Application No: FG/94/20/HH
Site Address: 7 Little Drive Ferring BN12 5RF
Description of works: Conversion of roofspace to habitable use and conversion of roof from hip to gable end and single storey rear extension.

Thank you for your internet representation made on 21st September 2020 which has been recorded as an objection with the comments as follows:

Roof Development +
Conversion Of Existing
Conservatory, To Full
Habitable Use.
7 Little Drive, Ferring,
West Sussex. BN12 5RT

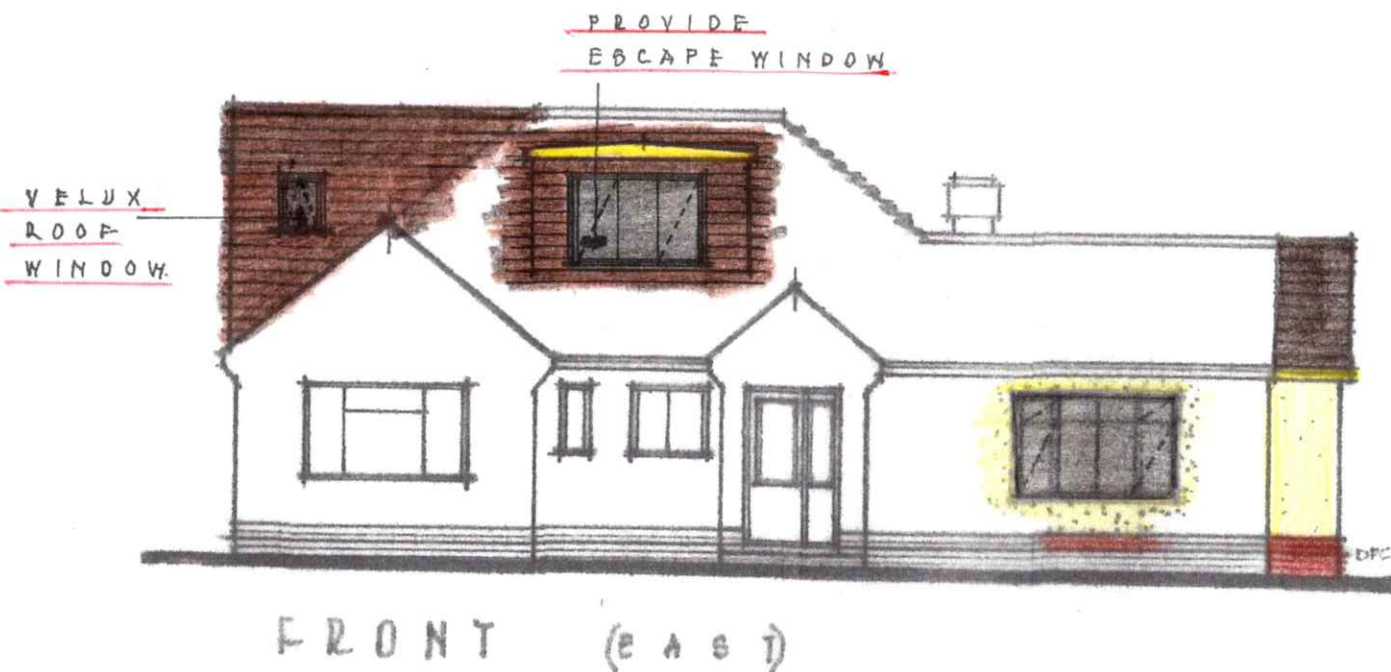
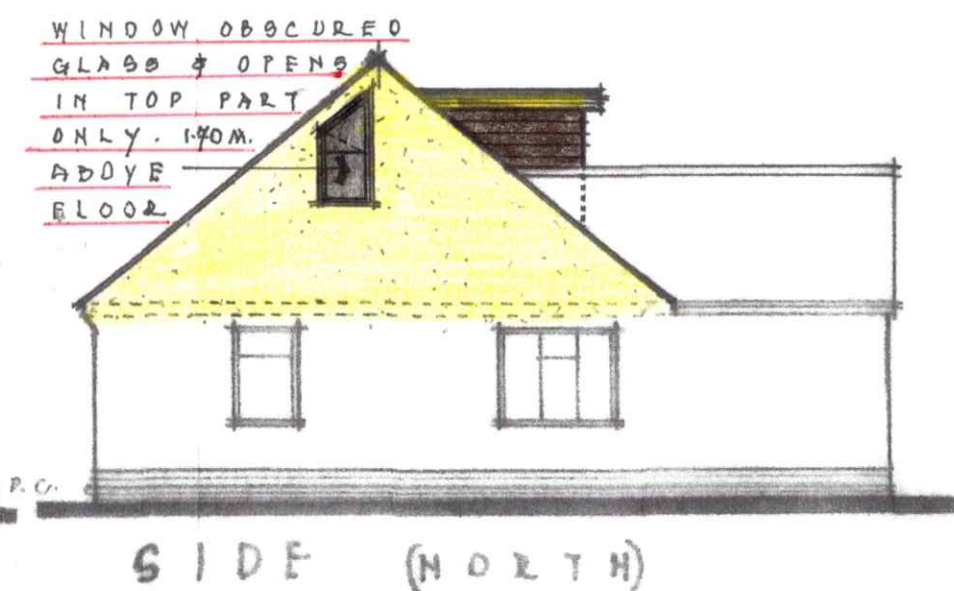
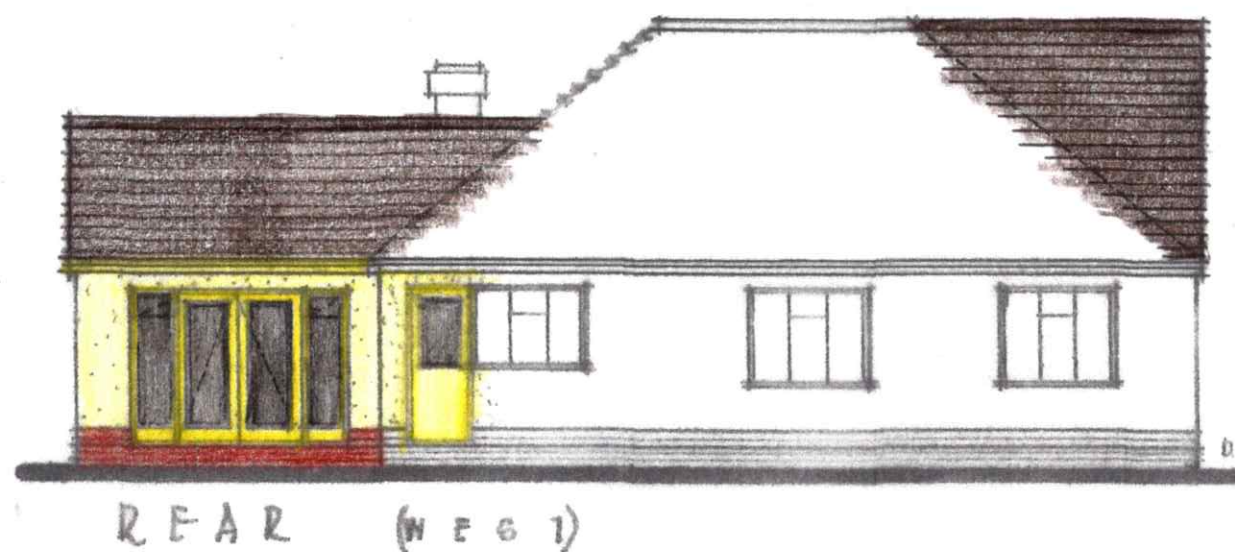
The proposed development is out of size and character of the neighbouring properties, the dormer will be directly overlooking the adjacent properties at 11 Little Drive and 14 Upper West Drive. The conversion of the hipped end to a gable end on the north elevation will also directly overshadow number 8 Little Drive and our property to the west.

Existing Plan,
Section And
Elevations Of
Property.

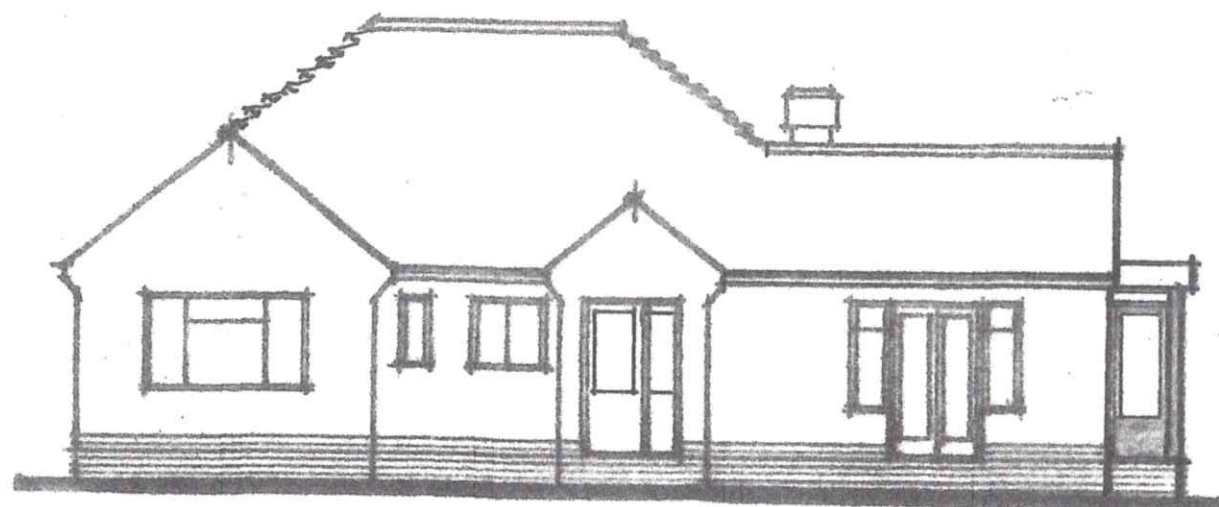
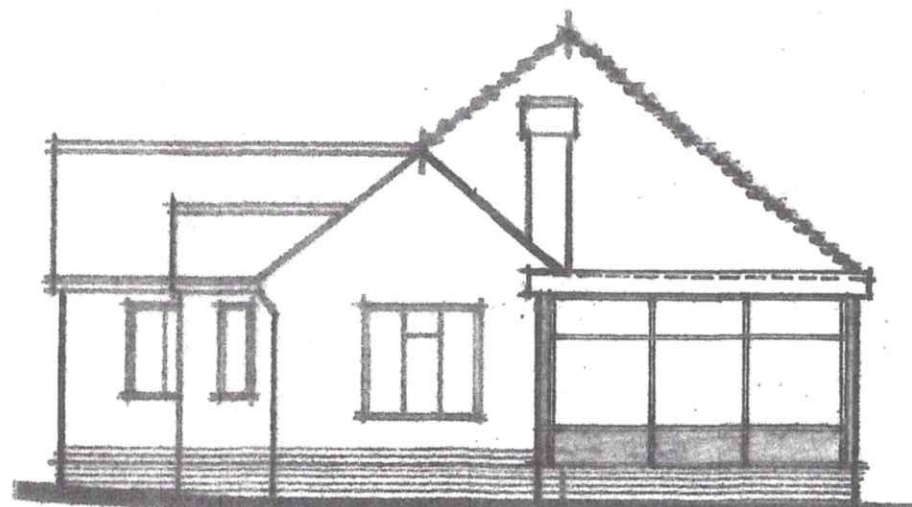
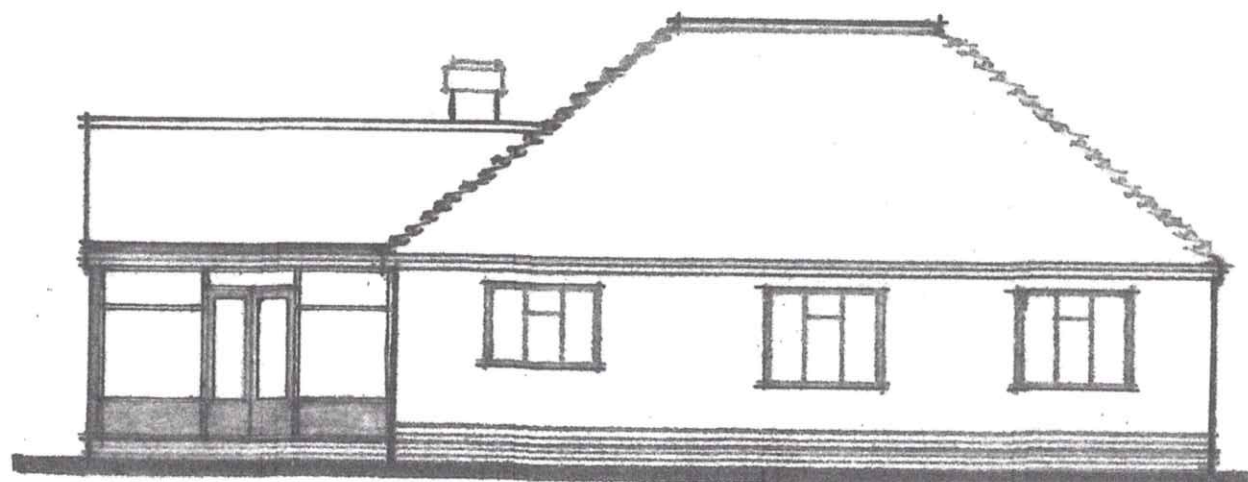
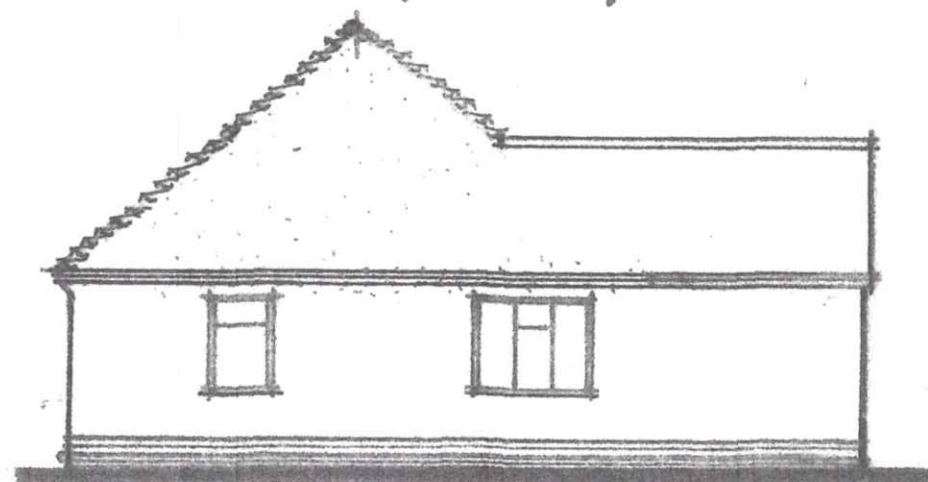
The plans submitted are not representative of the existing structure at the time of the application and the elevations are incorrectly marked. The owners of the property have already commenced works on the rear extension without planning consent. There was formerly a wooden glazed conservatory with a glazed flat roof on the south east corner of the property. This has been demolished and replaced with a new extension, with concrete cavity walls and a new pitched tiled roof altering both the footprint of the building and roofline, this is not shown on their planning submission as having already being completed. The photos submitted as part of this planning application are out of date and are not representative of the actual structure at the time of this planning submission either. This would appear to be an attempt to deceive both Arun Council Planning Department and all those parties affected by the proposal. The elevation drawings have also been incorrectly labelled, the front of the property faces west and the rear is in an easterly direction, however the front is indicated as east on the plan and the rear as west.
